Response to Planning application from Hertfordshire County Council (T and CP GDP Order 2015)

District ref: 6/2021/2873/HOUSE
HCC ref: WH/9873/2021
HCC received: 22 November 2021
Area manager: Matthew Armstrong
Case officer: Paul Marshall

71 PINE GROVE BROOKMANS PARK HATFIELD AL9 7BL

Alterations to front boundary to create new masonry wall and railings with electric gates

DRAWING TITLE :
Existing Front Garden Plan

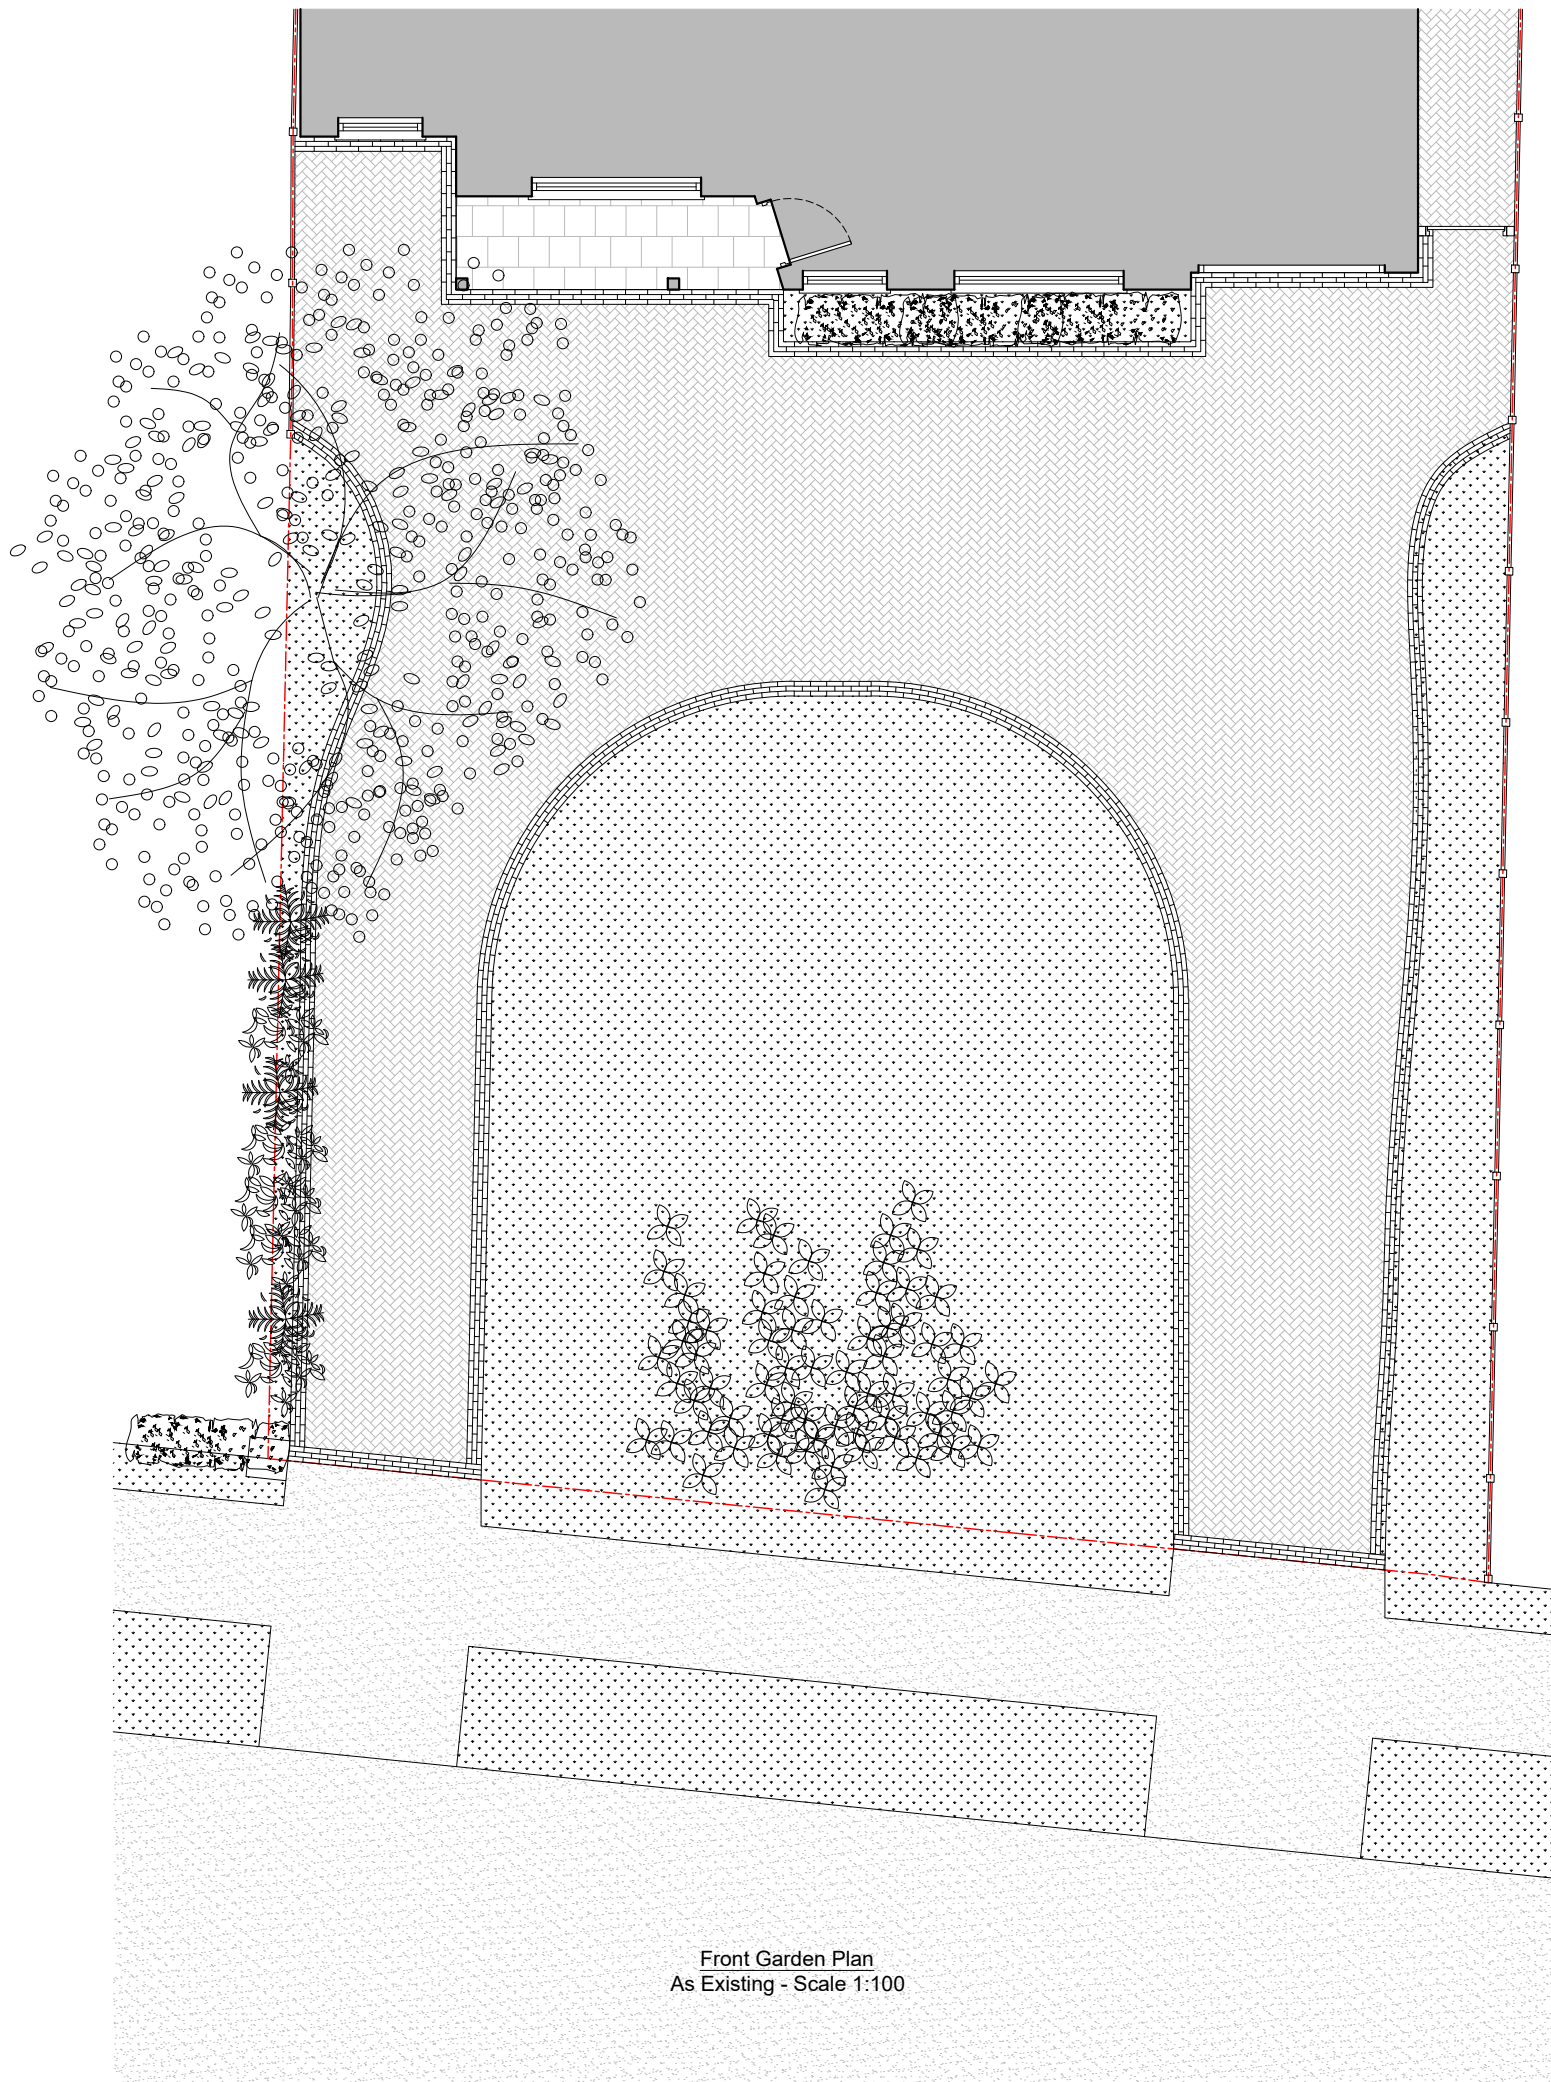
The available parking area is approx. 14.0m x 13.0m. This is adequate for vehicles entering and exiting in a forward gear. Any new hard standing / driveway should be of a bound material to reduce the risk of loose surface dressings entering the highway.

The location and vehicular to vehicular visibility from the existing access is considered to be acceptable and in accordance with 'Manual for Streets (MfS)' and 'Roads in Hertfordshire: A Design Guide'. However, a pedestrian visibility splay must be provided. A triangular vision splay must be provided on each side of the access and measure 2 metres along the fence, wall, hedge or other means of definition of the front boundary of the site, and 2 metres measured into the site at right angles to the same line along the side of the access drive. The vision splays on land under the applicant's control must be maintained free of any obstruction within which, there must be no obstruction to visibility between 0.6 metres and 2.0 metres above the carriageway.

CON1) Prior to the first occupation of the development hereby permitted 2.0 x 2.0 metre pedestrian visibility splays shall thereafter be retained at all times to each side of the access. They shall be measured from the point where the edges of the access way cross the highway boundary, 2.0 metres into the site and 2.0 metres along the highway boundary therefore forming a triangular visibility splay. Within which, there shall be no obstruction to visibility between 0.6 metres and 2.0 metres above the carriageway.

Proposed Front Garden Plan

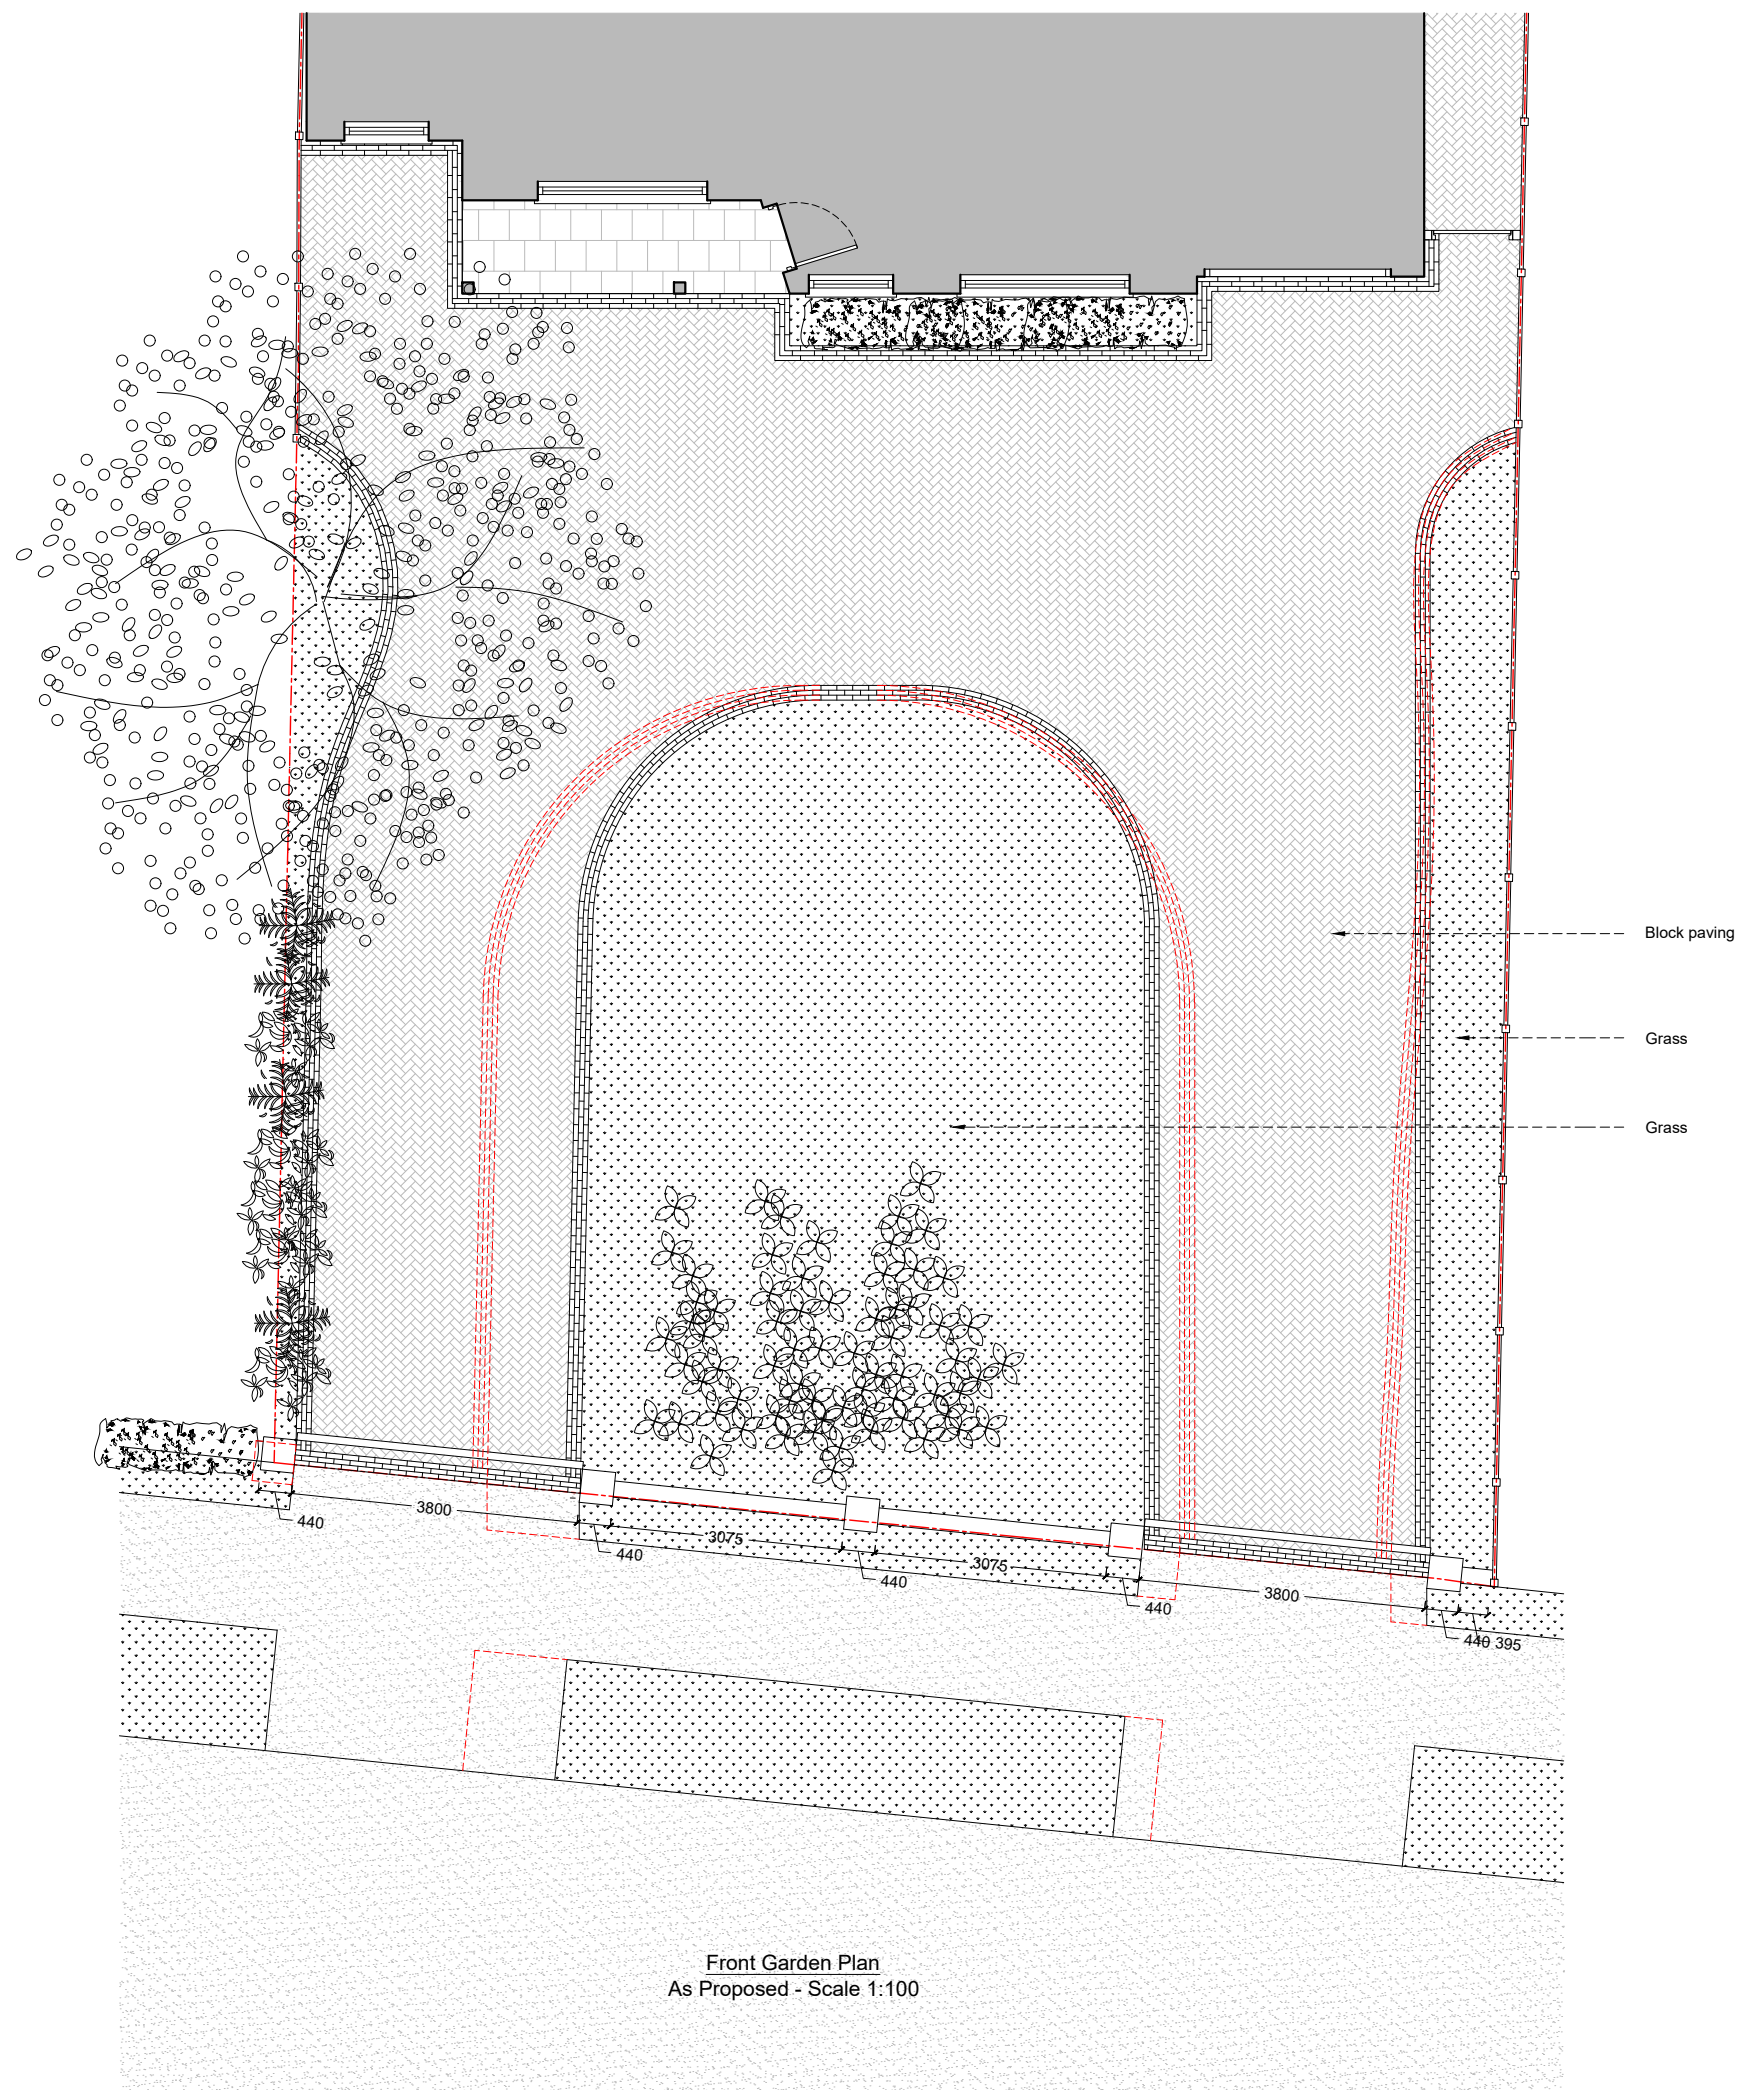
CON2) Prior to the first occupation of the development hereby permitted any access gates shall be installed to open inwards, set back, and thereafter retained (in perpetuity) at a minimum distance of 5.5 metres from the edge of the highway.

No new access is proposed the existing two access forming a 'U' shape carriageway style access. Two new gates are proposed which are set back from the back edge of the carriageway (as shown on drawing P1) by 3.8m This does not comply with Roads in Herts Section 4 – Design Standards and Advice Chapter 1 – Road Design Criteria, 1.9. The recommended distance must be 5.5m to allow vehicles to draw safely off the carriageway without impeding other road users (see condition above)
